From: Andy French [REDACTED]
Sent: 14 May 2026 17:09
To: Paul Cann <Paul.Cann@arun.gov.uk>
Cc: Joe Dixon <Joe.Dixon@arun.gov.uk>; Kathryn Welch <Kathryn.Welch@arun.gov.uk>
Subject: RE: Response to A-30-26-PL - Highdown Garden Centre 2 - v2 080526

0. General

Drawing No: A9803 - 140 P2

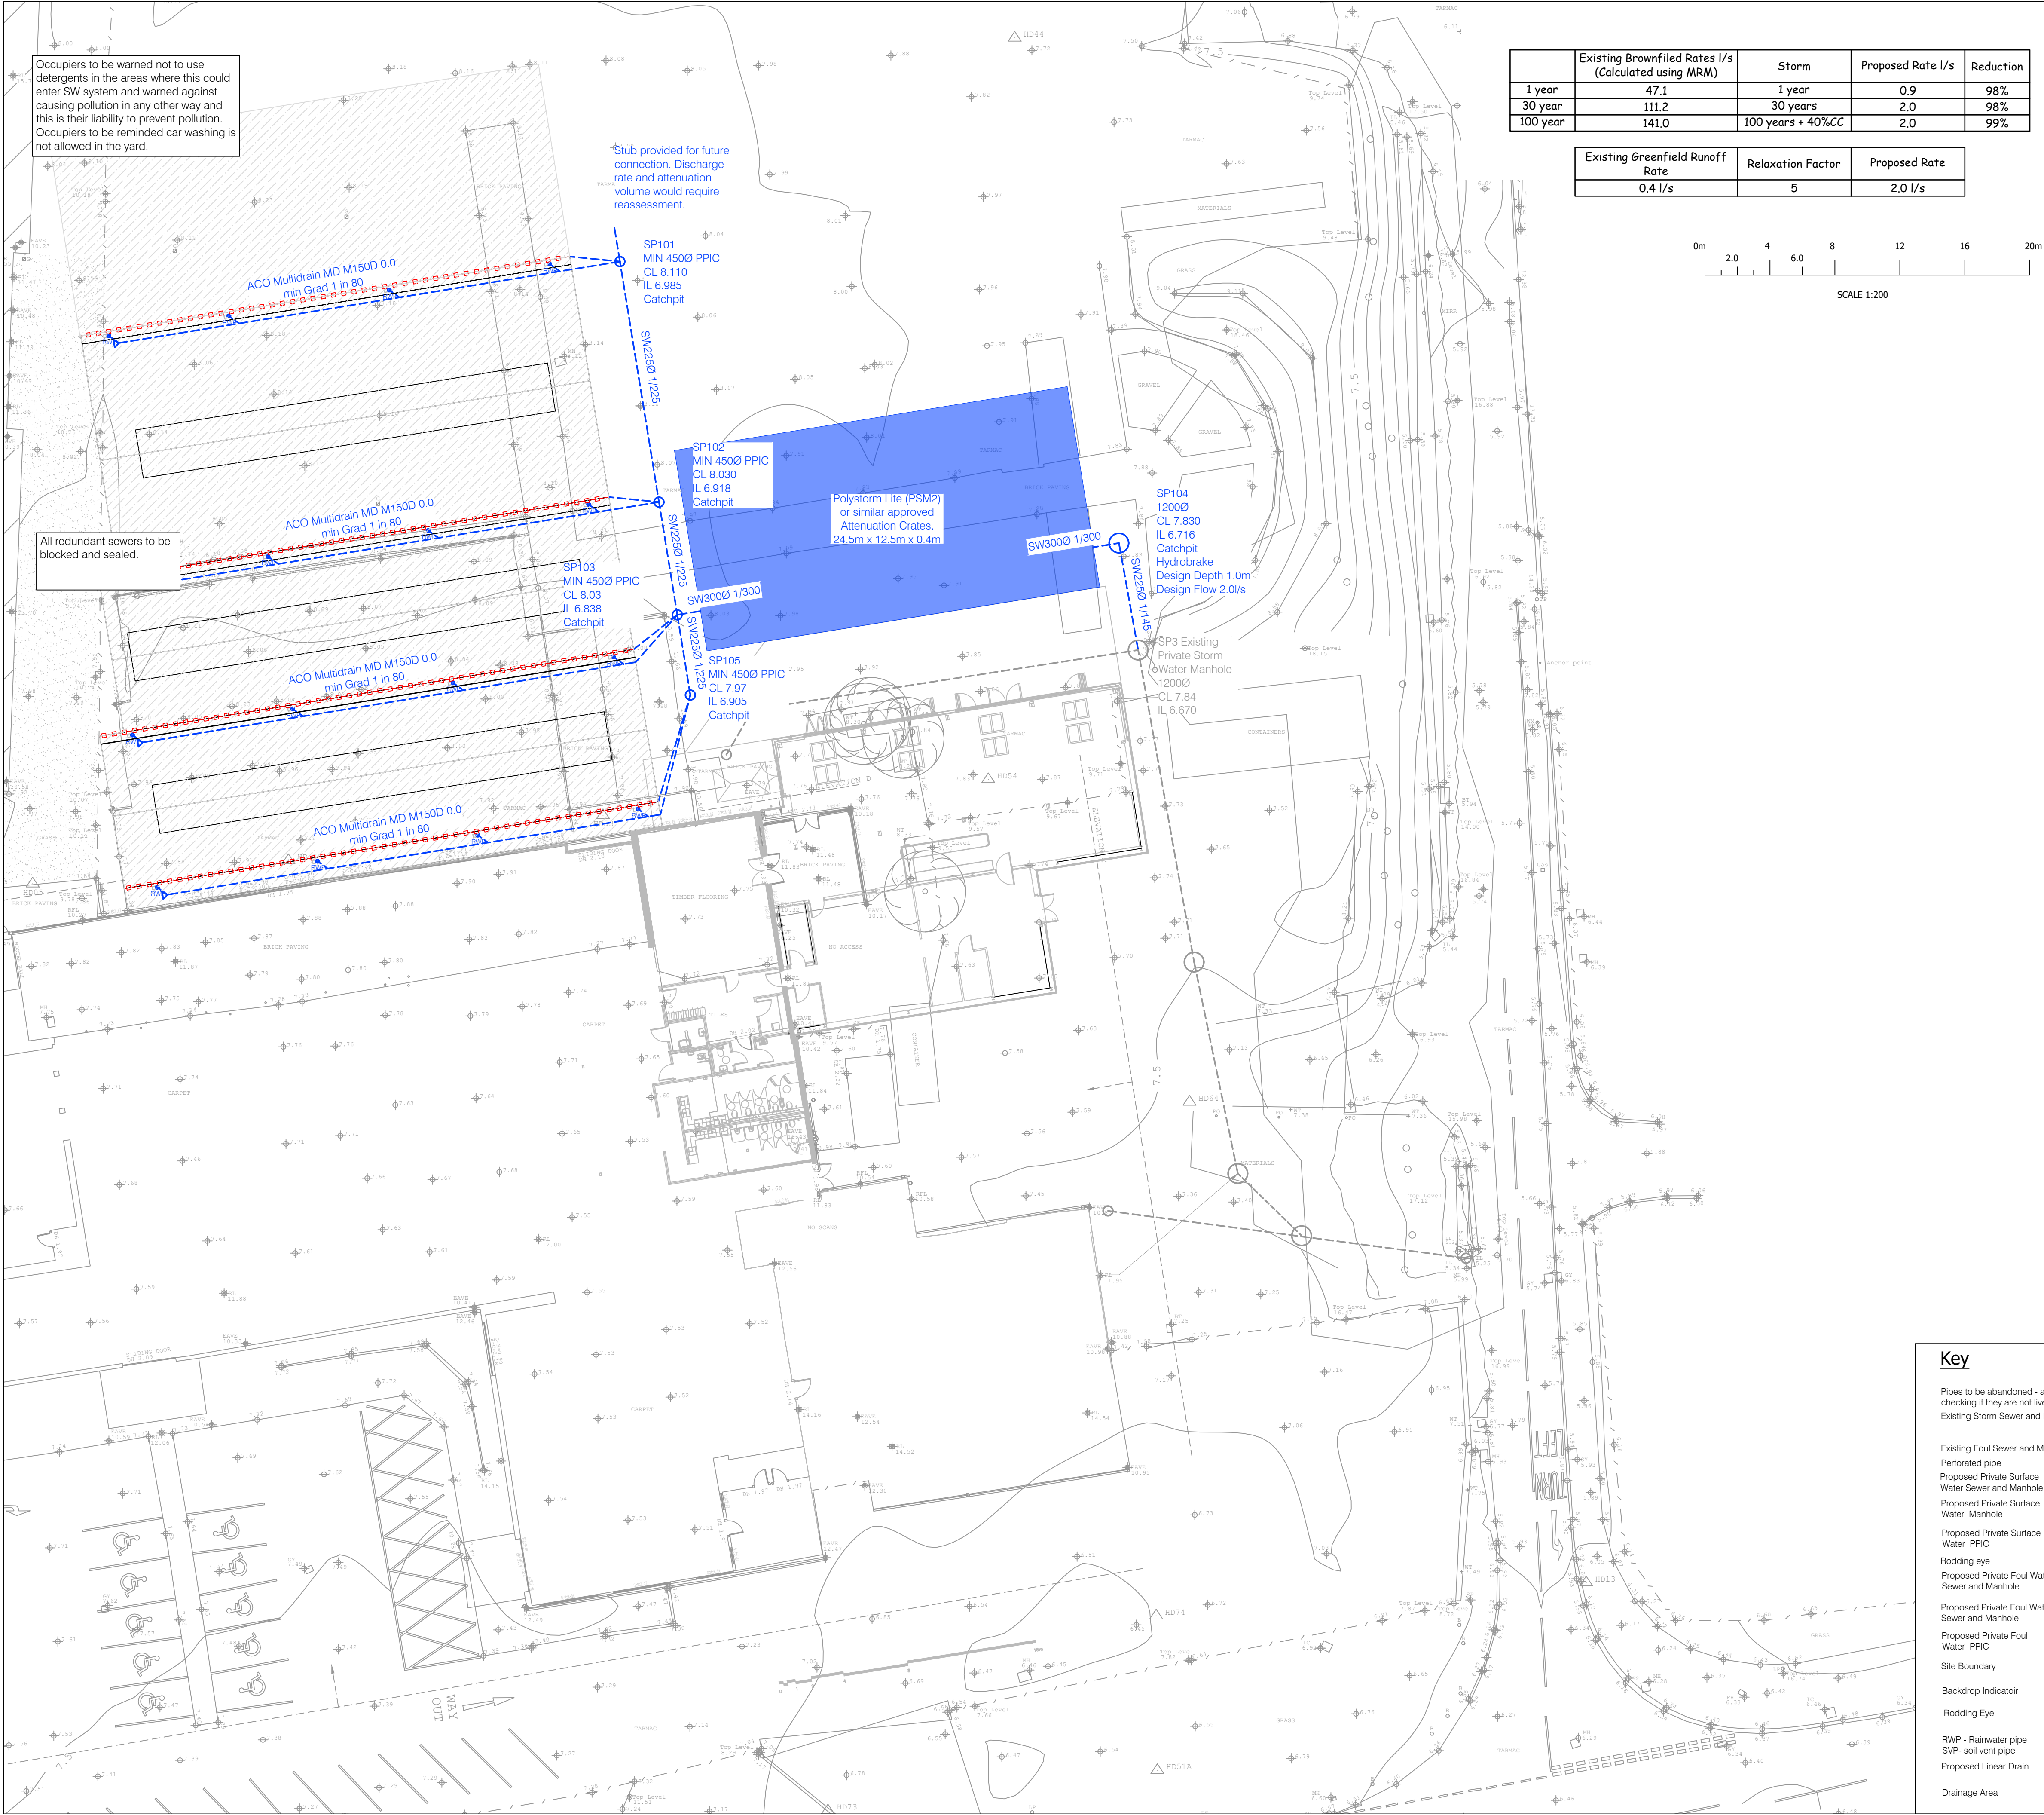
This should be clarified on the submission plans, the drainage layout currently does not show the site boundary.

1.1. The proposed drainage layout shows a piped restricted outlet to the existing drainage system at the site. The downstream outfall is unclear but there is a piped ordinary watercourse shown on our records in the location.

Typically a planning stage drainage design would identify the outfall and receiving body beyond the end of the pipe. Hangleton Lane is a public highway maintained by WSCC, The watercourse sections are not owned or maintained by ADC. We do have GIS data on the watercourse which indicates connectivity to an ordinary watercourse. There are riparian ownerships and it is not clear from the submission whether the outfall is within the site. This is a key aspect we check at planning stage.

The drainage drawing was unclear and could highlight the site boundary and the receiving watercourse. We have reviewed the GIS data held by the Council and have reasonable confidence the outfall is to the ordinary watercourse. A photo would be useful thank you.

- 2.1. Interception drainage is not currently incorporated into the design.

- 3.1. The calculations provided are not in accordance with ADC criteria. The latest rainfall profiles are not used, CV values are low, the peak outflow is not related to greenfield runoff.
- 3.2. Guidance is provided on ADC webpages - <https://www.arun.gov.uk/surfacewater>.
- 3.3. Management of extreme rainfall is not currently in accordance with the requirements of the NSfS Standard 3. Therefore, we **object** to the application.

The piped outfall position and size is shown on the drainage drawing provided. Please advise what further information you require, it is the end of a pipe. We can take a picture from Hangleton Lane if required. Given your existing involvement with WSCC we would imagine you have significant information on the arrangement of all drainage discharge along Hangleton Lane which is maintained by ADC.

We have provided the drainage layout for existing and new showing the outfall. We are happy to provide a photo from Hangelton Lane of the existing end of the pipe where it leaves our site.
